Department of Transportation

US-24G
El Paso County

April 29, 2026

RE: Kyle Rezone (P264)

**Figure 6**  
**TOTAL TRAFFIC - YEAR 2027**  
 Volumes & Intersection Geometry  
 AM / PM Peak Traffic Hour  
 (ADT) : Average Daily Traffic

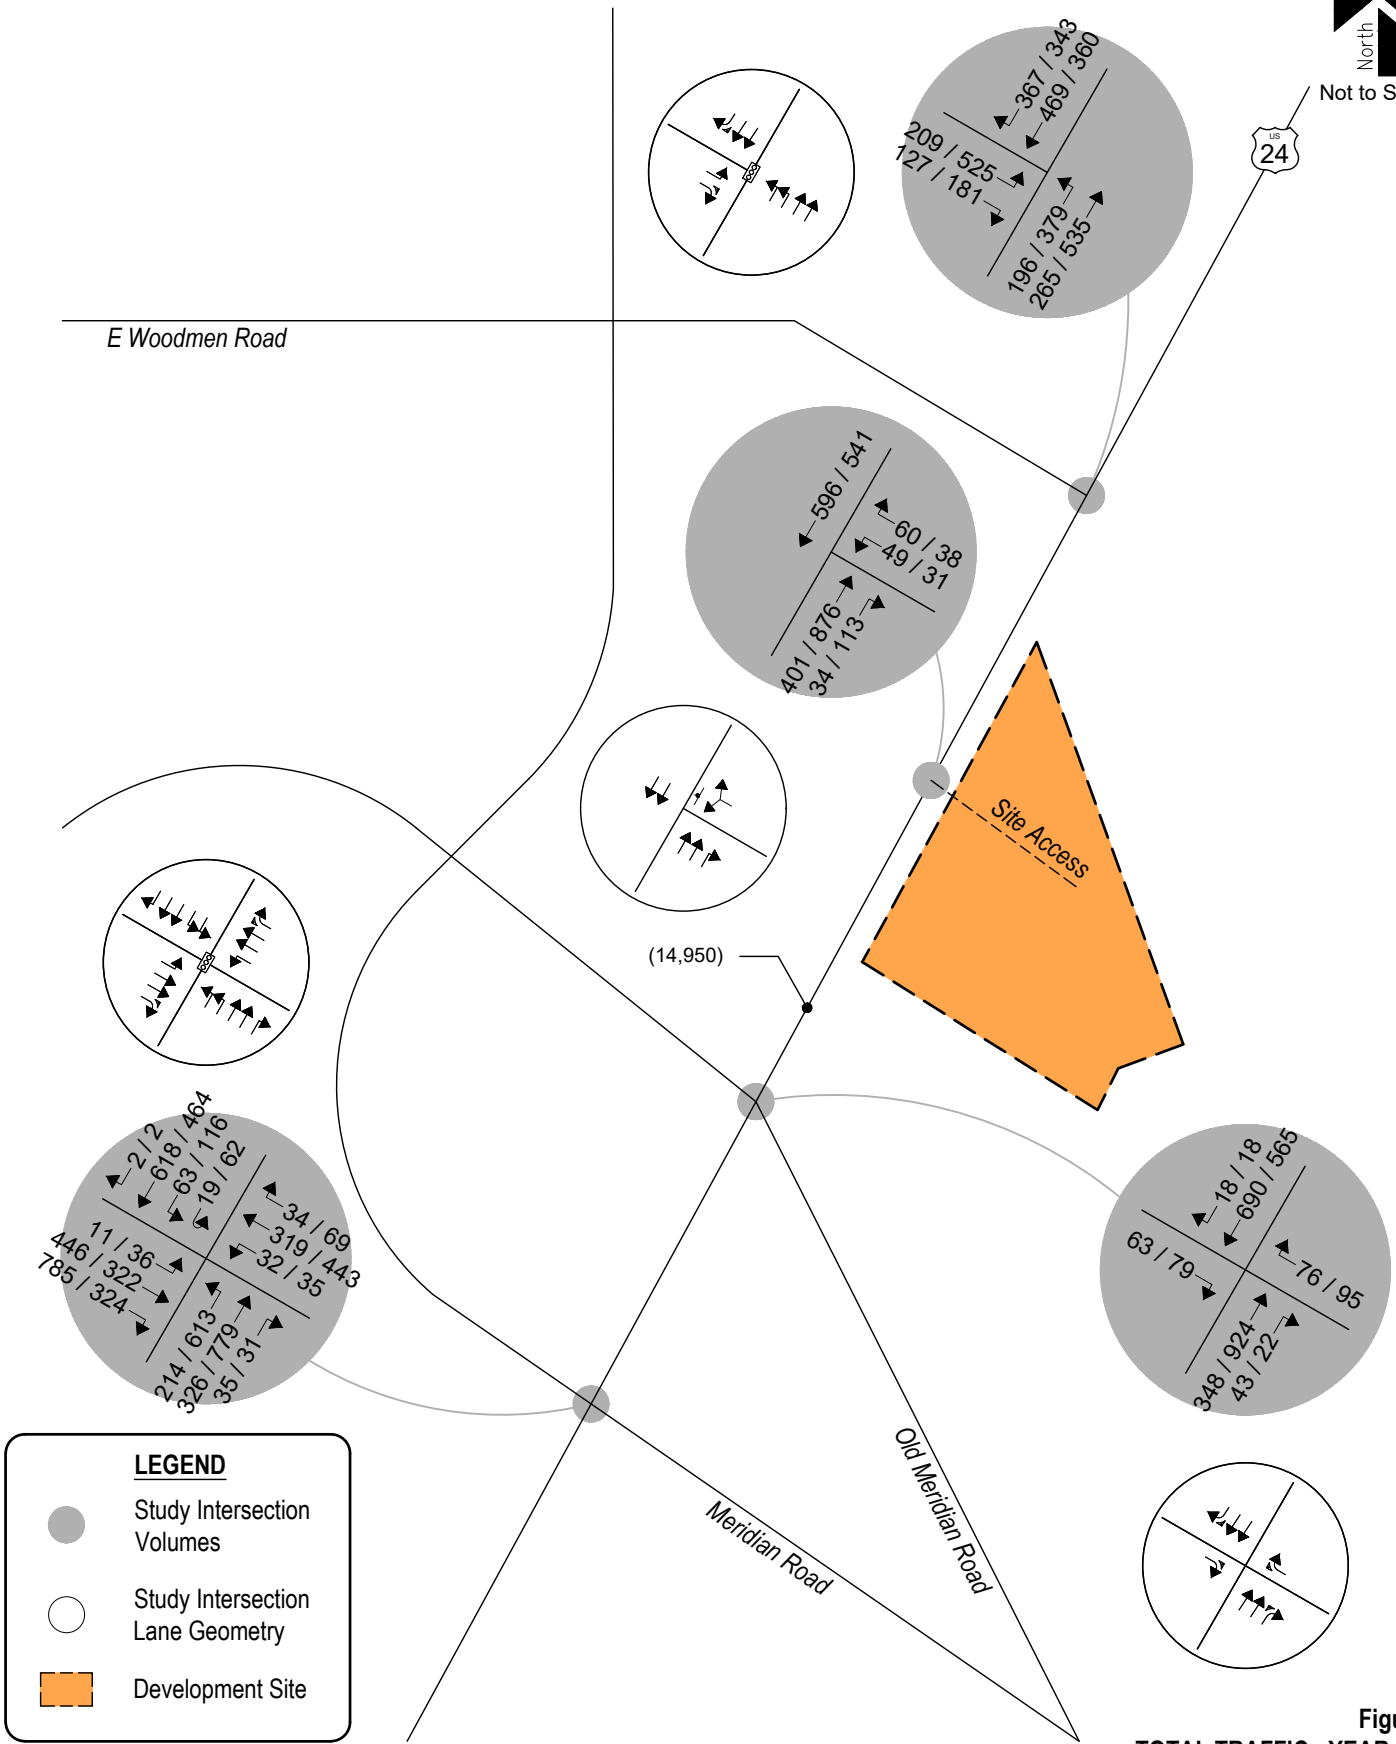
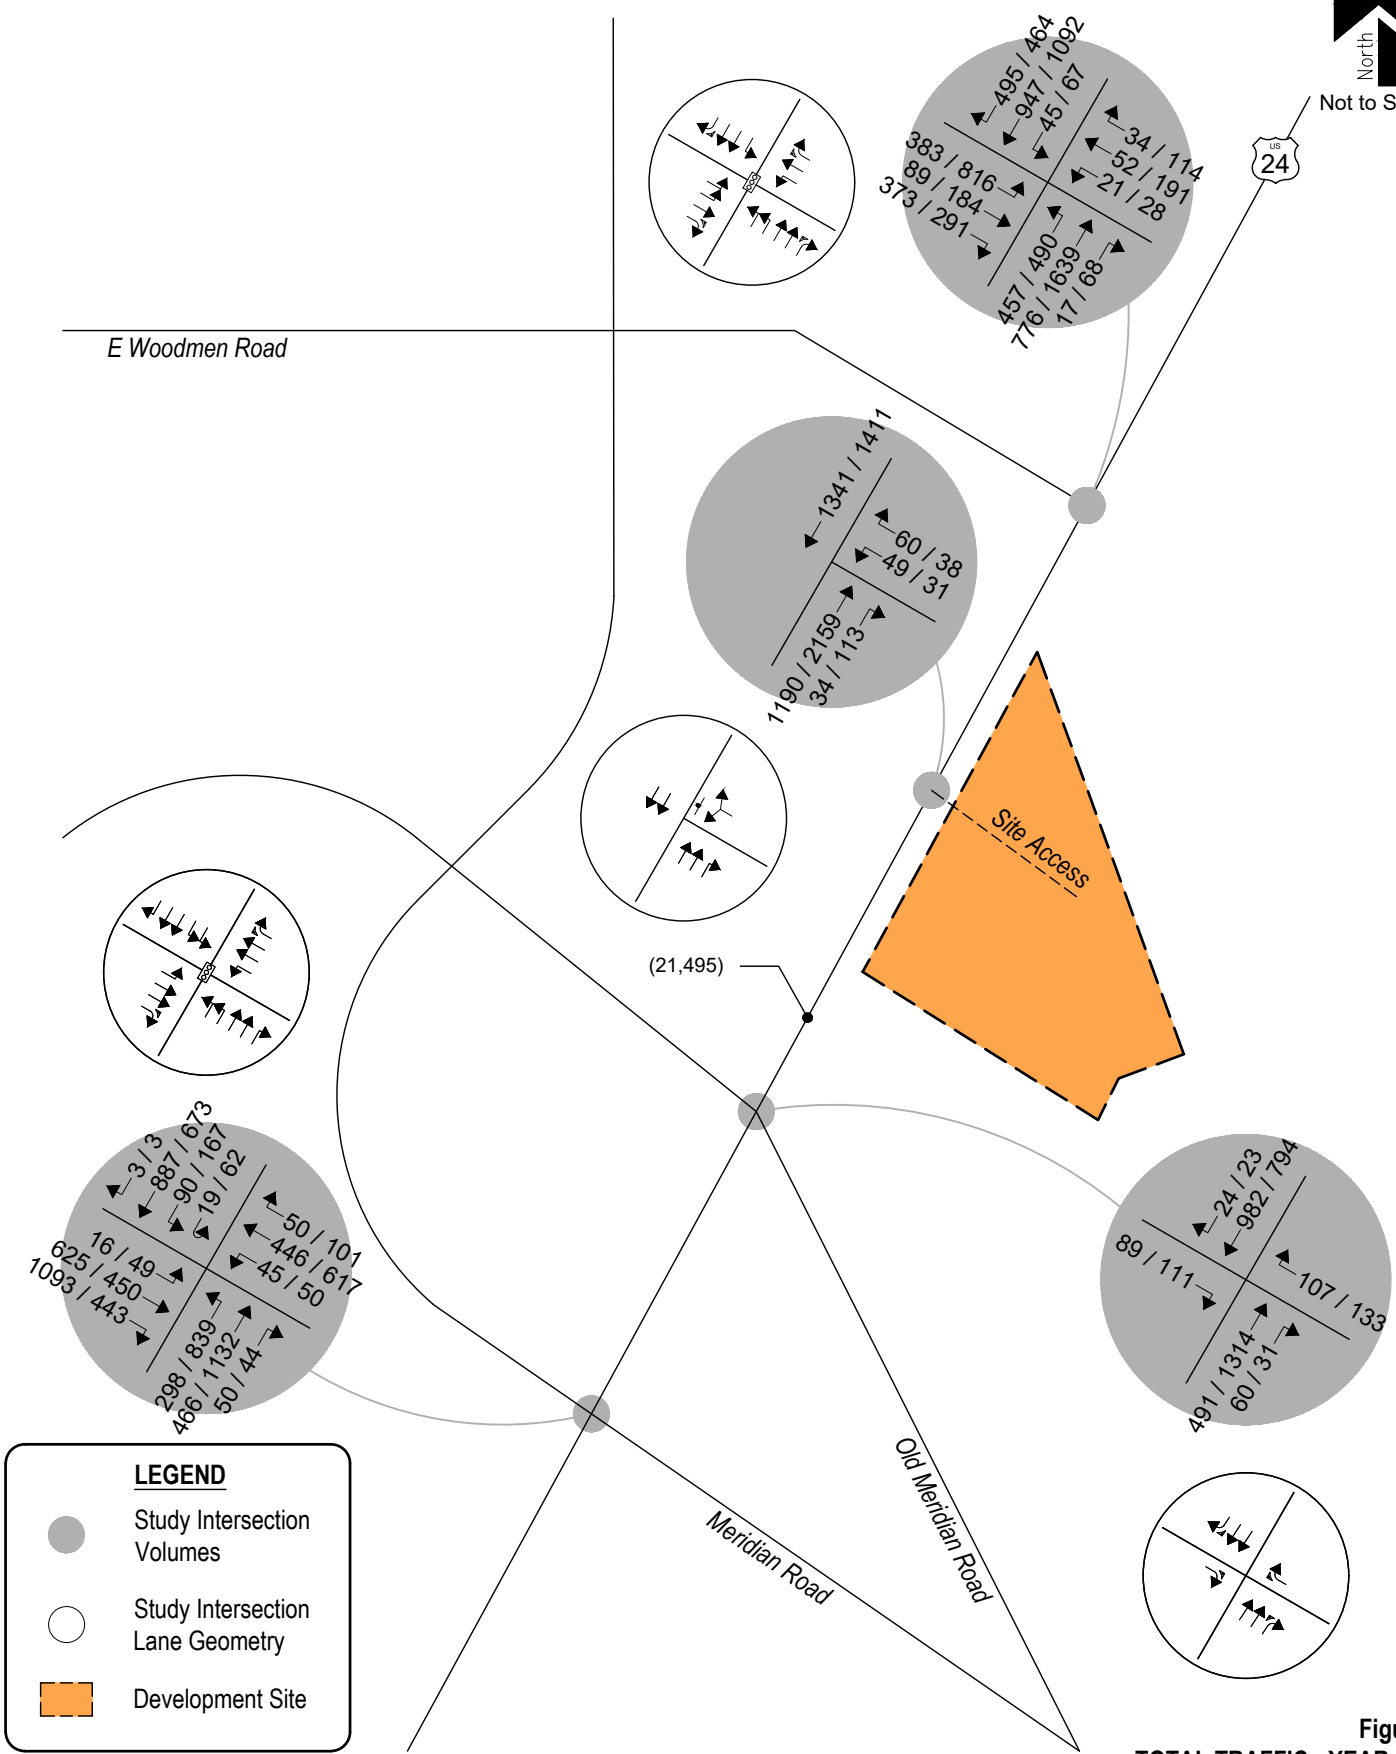
- CDOT rejects the Traffic Impact Study for 12057 Highway 24 Multifamily Rezone dated January 2026, revised April 2026 as it still shows a three-quarter access with left turns out onto US Highway 24 from the site. This does not match the Access Control Plan for US24G.

- Our comments from our letter dated March 3, 2026 remain the same. They are as follows:
 - CDOT Project #25094 is reconstructing US-24G to include an additional thru lane in each direction, auxiliary turn lanes at the intersections, and a center raised median. The proposed full-movement access onto US-24G will be constructed as a right-in/right-out as a part of the CDOT project.

Please revise the Traffic Impact Study to reflect changes in driveway movements and resubmit for review.
